# KITTTITAS COUNTY COMMUNITY DEVELOPMENT SERVICES

Subject: Williams Shoreline Substantial Development Permit (SD-18-00001)  
Second Request for Information

**TO:** Chelsea Benner, Planner I  
**COPY:** Taylor Gustafson, Planner III  
**DATE:** October 19, 2018  
**FROM:** Mark R. Cook, Director   
**RE:** SD-18-00001 Williams

DRIVEWAY AND BRIDGE SITE PLAN
DRAWING 10

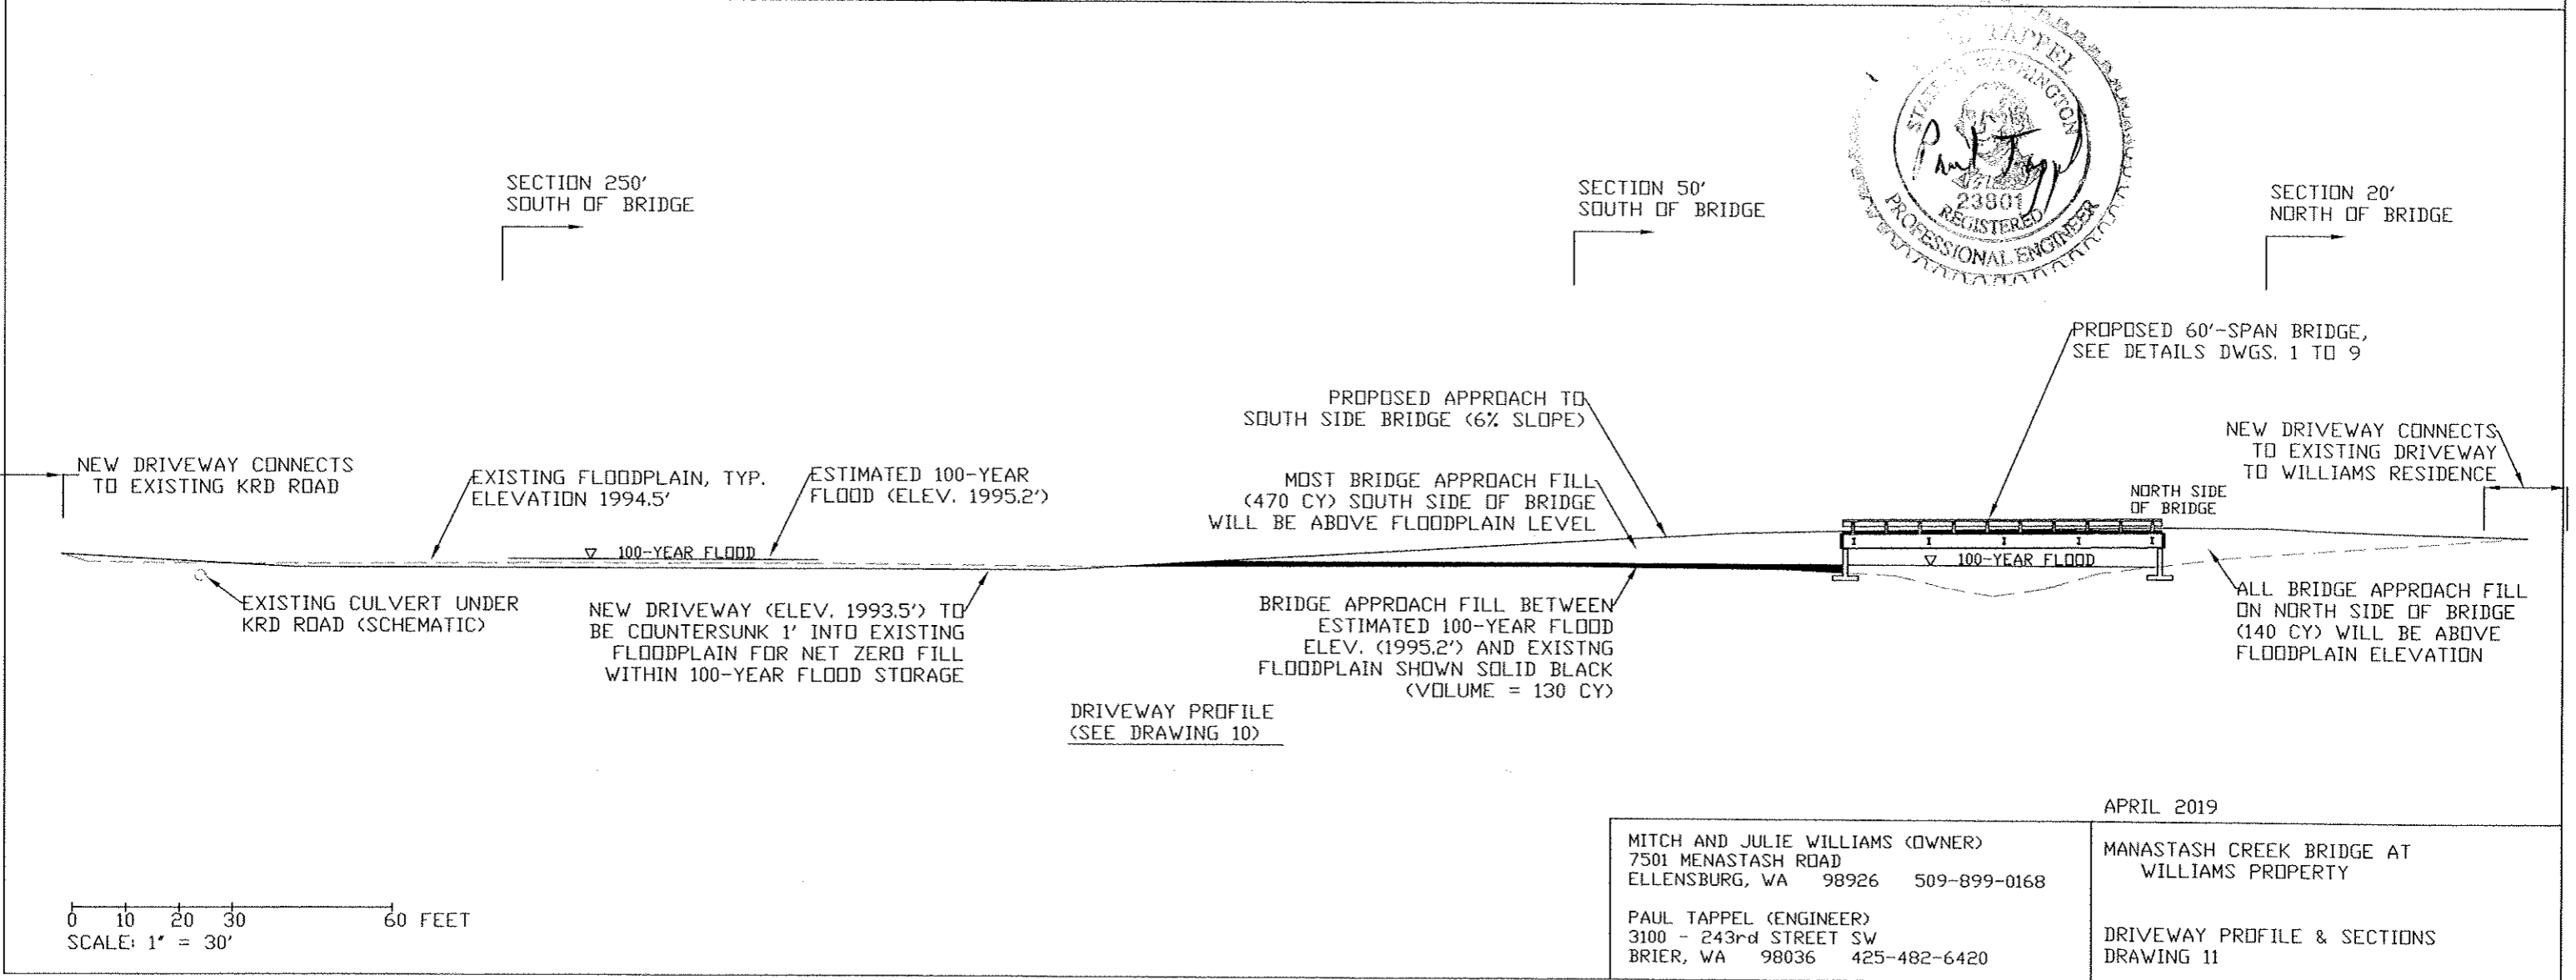
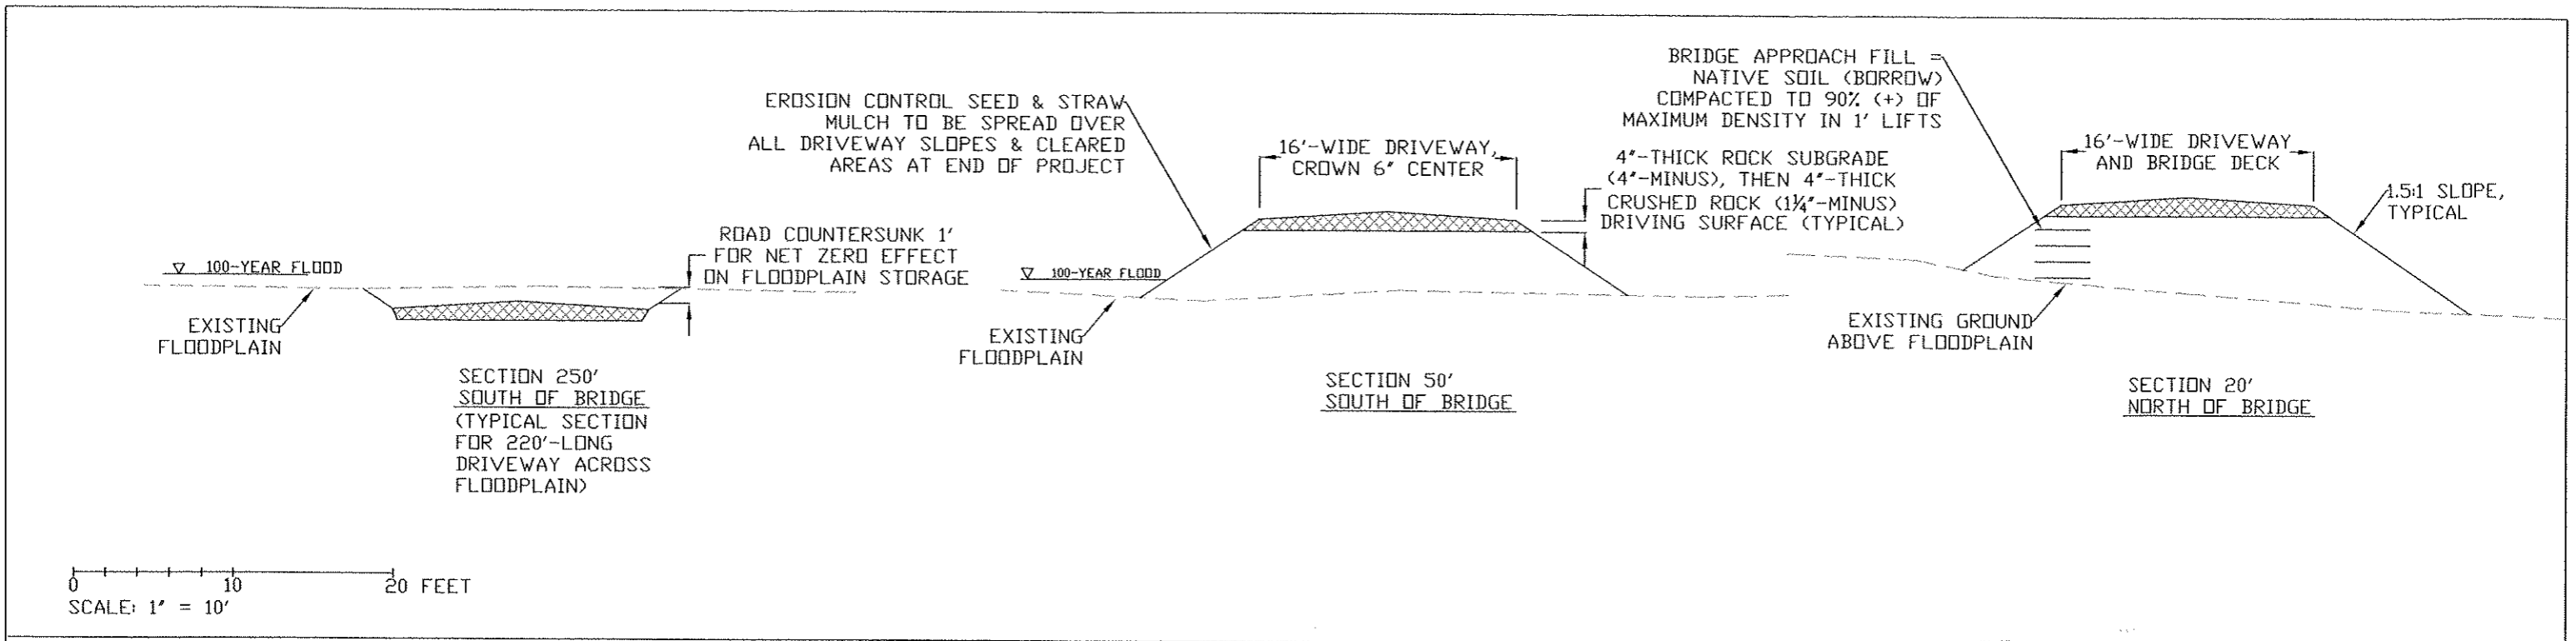
1. Detailed narrative covering specifications on the new portion of driveway to be constructed. The narrative must include:

- a. Type of fill
- b. Grading information (See enclosed Public Works Memo for specifics)
- c. Composition of proposed driveway
- d. Disturbed area measurements

1. The bridge specifications provide no engineering calculations. Prior to bridge design approval, supporting calculations and a load rating are required.
2. We do not see anywhere in the application the type, quantity, source and composition of driveway and bridge approach abutment fill is detailed.
3. We note that a 100 year flow volume is referenced but there are no supporting calculations. The flow volume is a necessary component of validating bridge freeboard.
4. The application materials do not identify the access location for the proposed new driveway. It is unclear if the proposed new access location has any implications to floodplain or shoreline.
